**Our ref:** NO/2025/116588/02-L01  
**Your ref:** 3/2024/0943

**Date:** 25 February 2025

**PROPOSED ERECTION OF EIGHT NEW AGRICULTURAL BUILDINGS FOR DAIRY CATTLE AND ASSOCIATED INFRASTRUCTURE TO INCLUDE: 1 X COVERED MIDDEN, 2 X PLANT ROOMS, 1 X CATTLE SHEDS WITH ROBOTIC MILKING MACHINES, 1 X CALVING SHED, EXTENSION TO EXISTING CALVING SHED, 1 X 1.5 STOREY STAFF ROOM/OFFICE AND ERECTION OF WASH DOWN AREA/FUEL STORAGE BAY. CREATION OF HARD STANDING, INSTALLATION OF 3 X SILO'S, AND INSTALLATION OF SUSTAINABLE DRAINAGE SYSTEMS.  
BLACK MOSS FARM, ELMRIDGE LANE, CHIPPING, PR3 2NY**

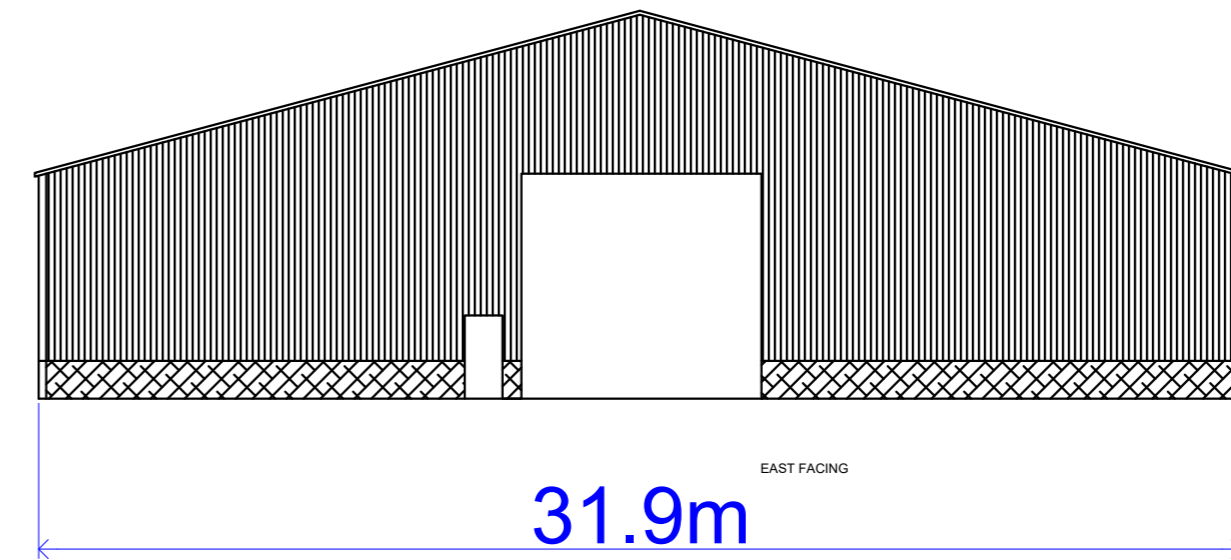
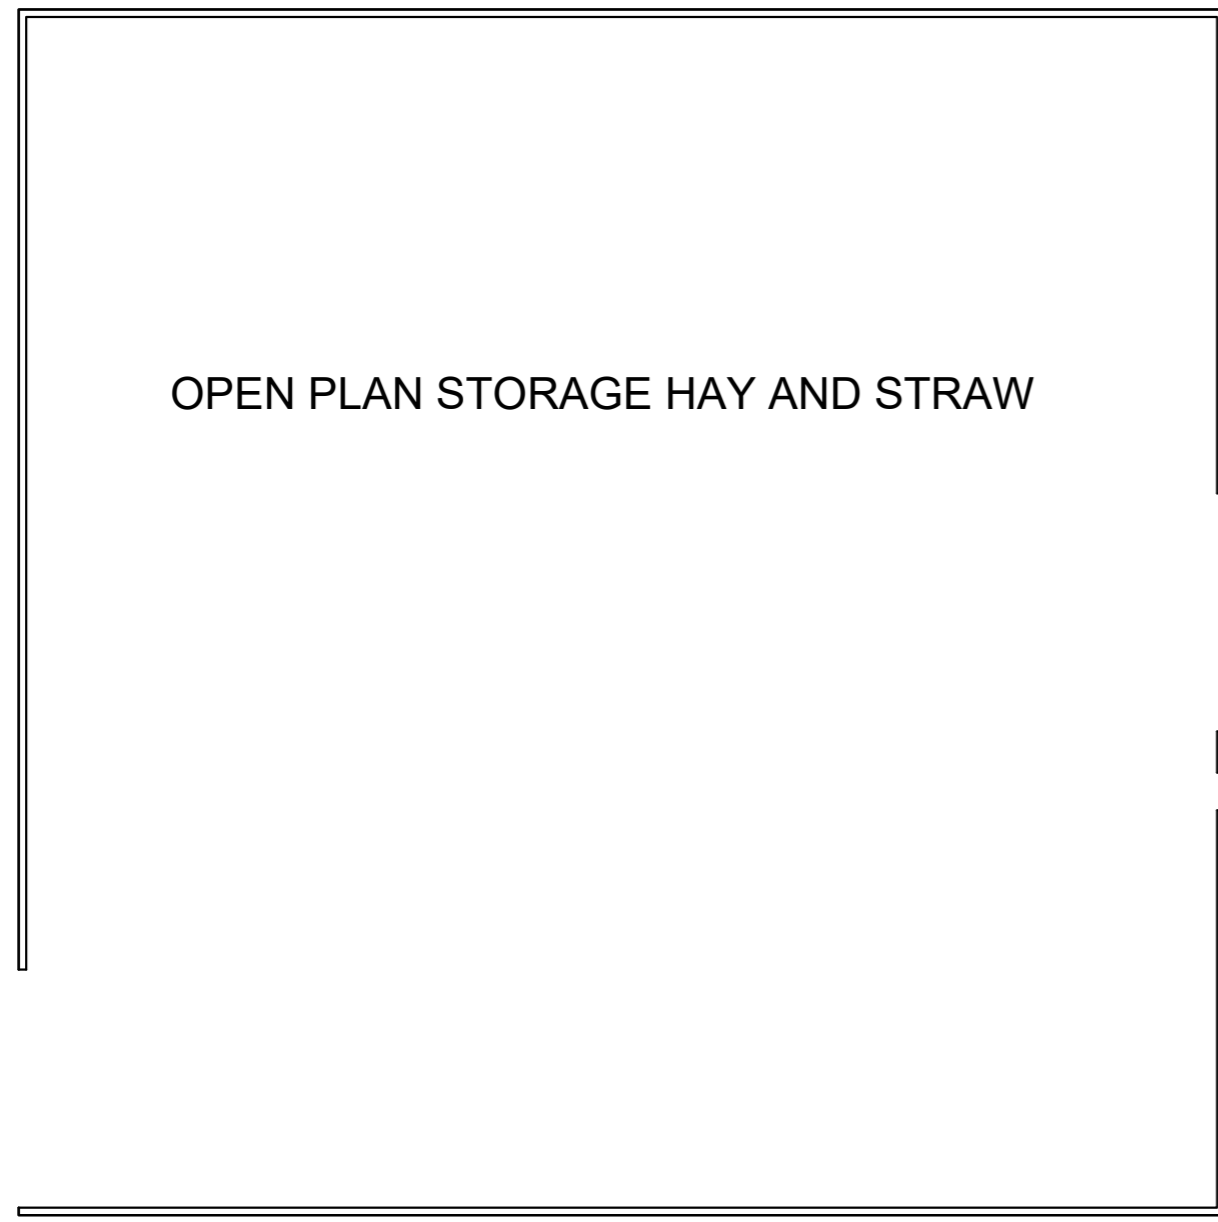
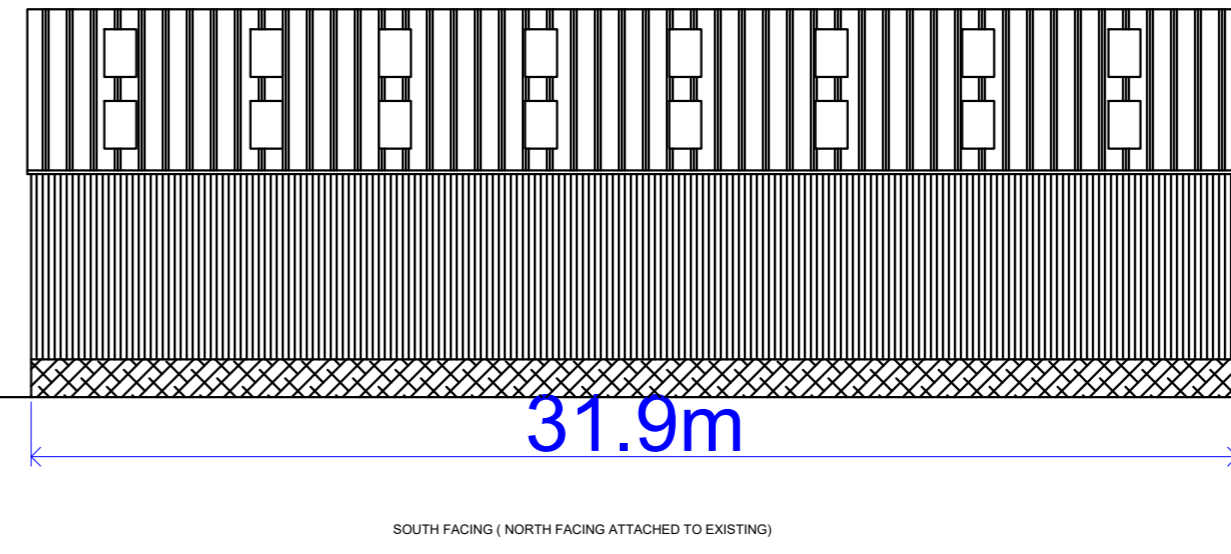
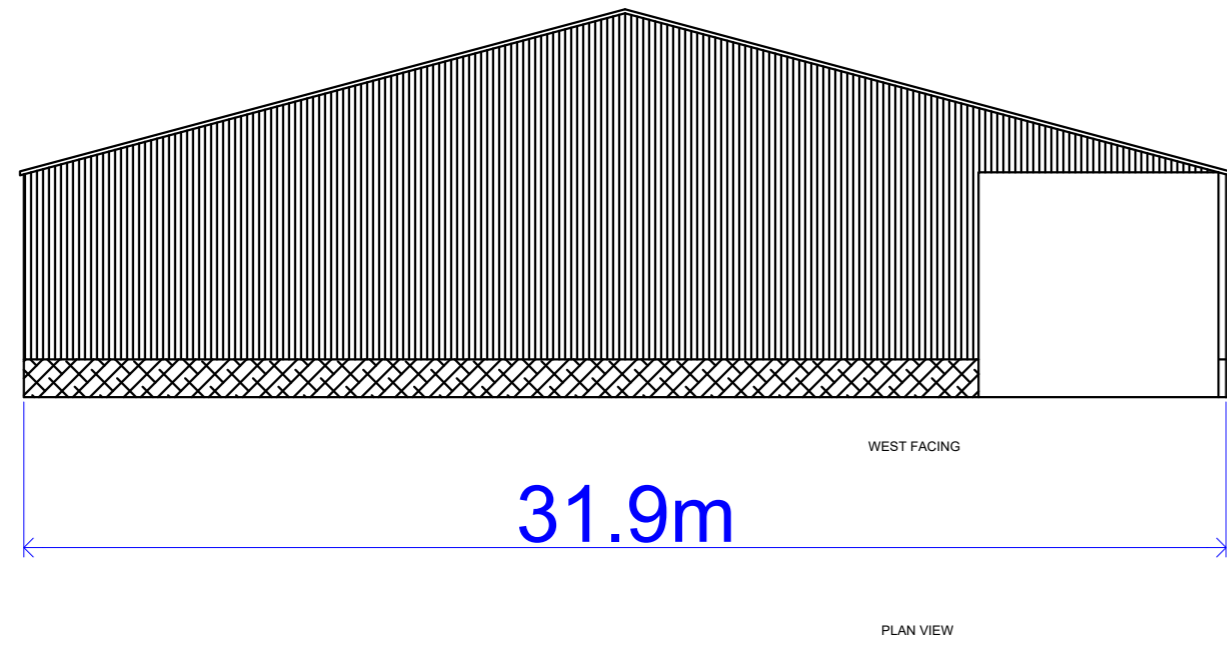
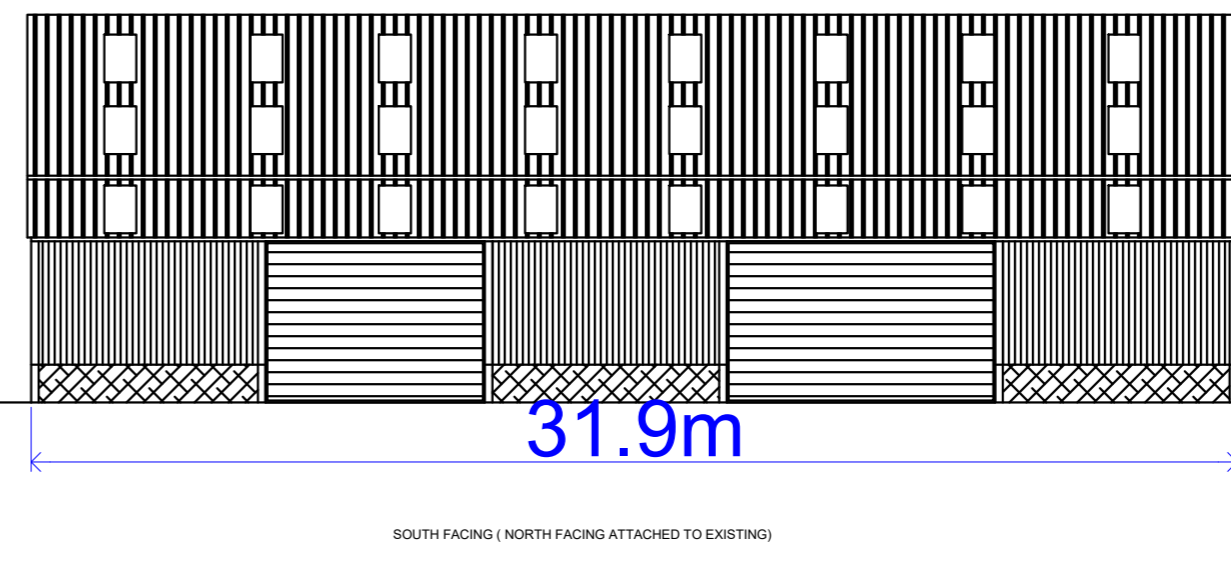
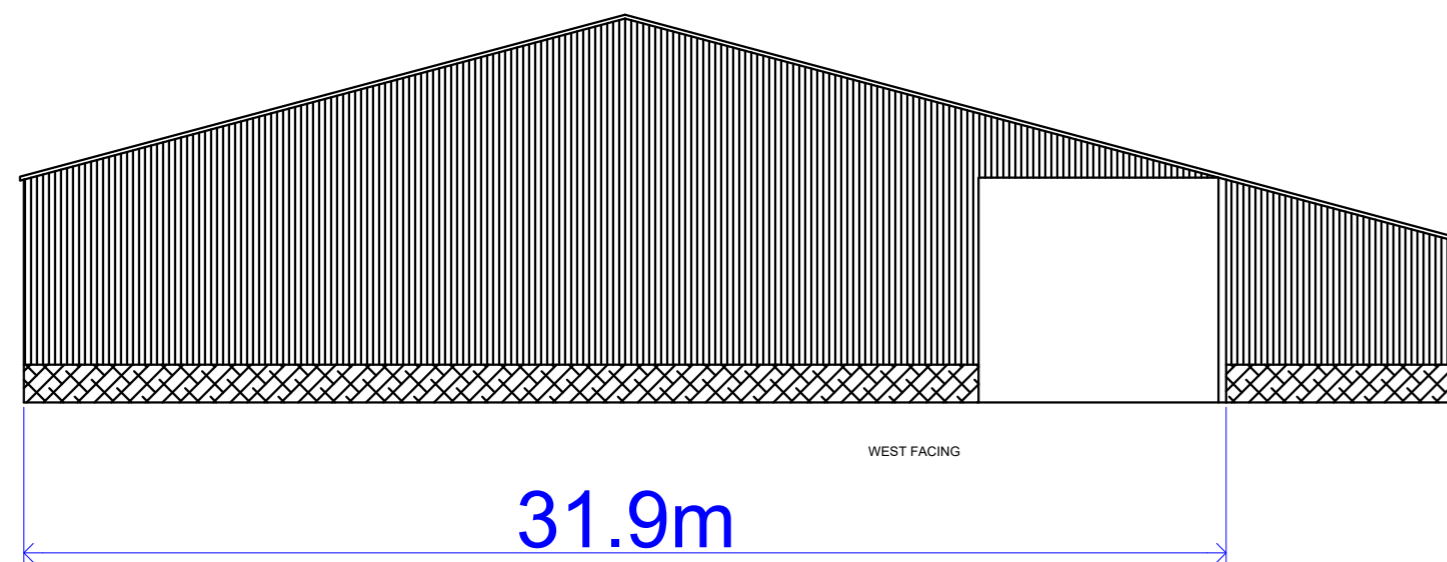
We note that as part of the proposal, there is a designated area within the plans for vehicle wash down and refuelling of farm vehicles. We have therefore reviewed the drainage plan submitted with the proposal entitled "Drainage Strategy Report", produced by Barnsley Marshall, reference CSH-BML-XX-XX-RP-C-0510, Rev P02, dated 8<sup>th</sup> August 2024. The report states that the proposal is to drain roof water on a separate system to foul flows from yard wash downs, including those from the refuelling/vehicle wash down area. We therefore have no objection to the proposed development however, we do have the following advice for the applicant.

Any facilities, above ground, for the storage of oils, fuels or chemicals shall be sited on impervious bases and surrounded by impervious bund walls. The volume of the bunded compound should be at least equivalent to the capacity of the tank plus 10%. All filling points, vents, gauges and sight glasses must be located within the bund. The drainage system of the bund shall be sealed with no discharge to any watercourse, land or underground strata. Associated pipework should be located above ground and protected from accidental damage. All filling points and tank overflow pipe outlets should be detailed to discharge downwards into the bund.
